Submission re ACP-324132-26 Killough Solar

Planning Report on proposed Electricity Development Application
in accordance with Section 182(A) of the Planning and Development Act 2000 (as amended)

An Comisúin Pleanála Ref. No:	ACP-324132-26
Applicant:	Marmoris Limited - Killough Solar
Proposed Development:	Proposed development of a 110kV GIS substation providing connection to the national grid via a loop in/loop out connection to the already existing Killhill - Thurles 110kV Overhead line and ancillary development
Development Location	Graigie, Co. Tipperary

**Figure 2 – Wireline Streetview montage from the local road that defines the western edge of Moycarkey Village. Montage view includes proposed mitigation planting to the fore of the substation.**

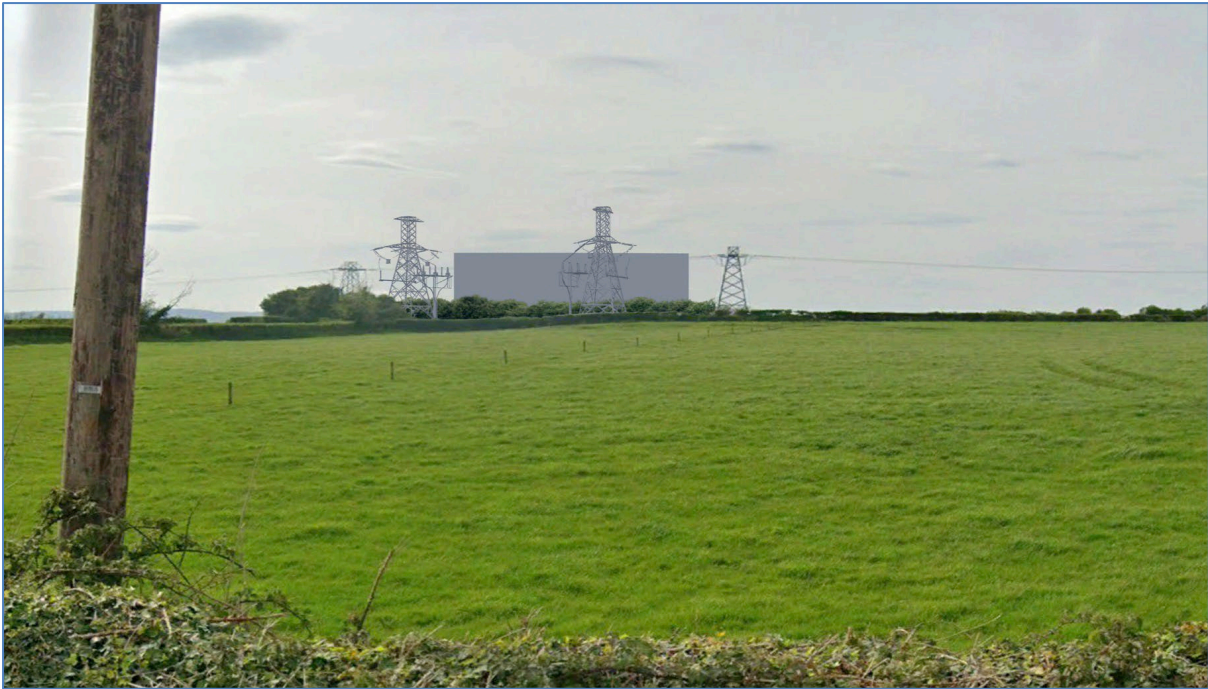
- The proposed GIS Building is a large structure with a floor area of 774 sq m and height of 16.5 metres, The Planning Authority is concerned with the height and scale of this building and its impact on the landscape. The submitted photomontages provide a limited representation of the development as it would appear from local roadways and residences. Photomontage VP13b illustrates the development as a discordant feature in the landscape.

The proposed GIS building, given its, height and form, is considered to be a discordant feature in the landscape.
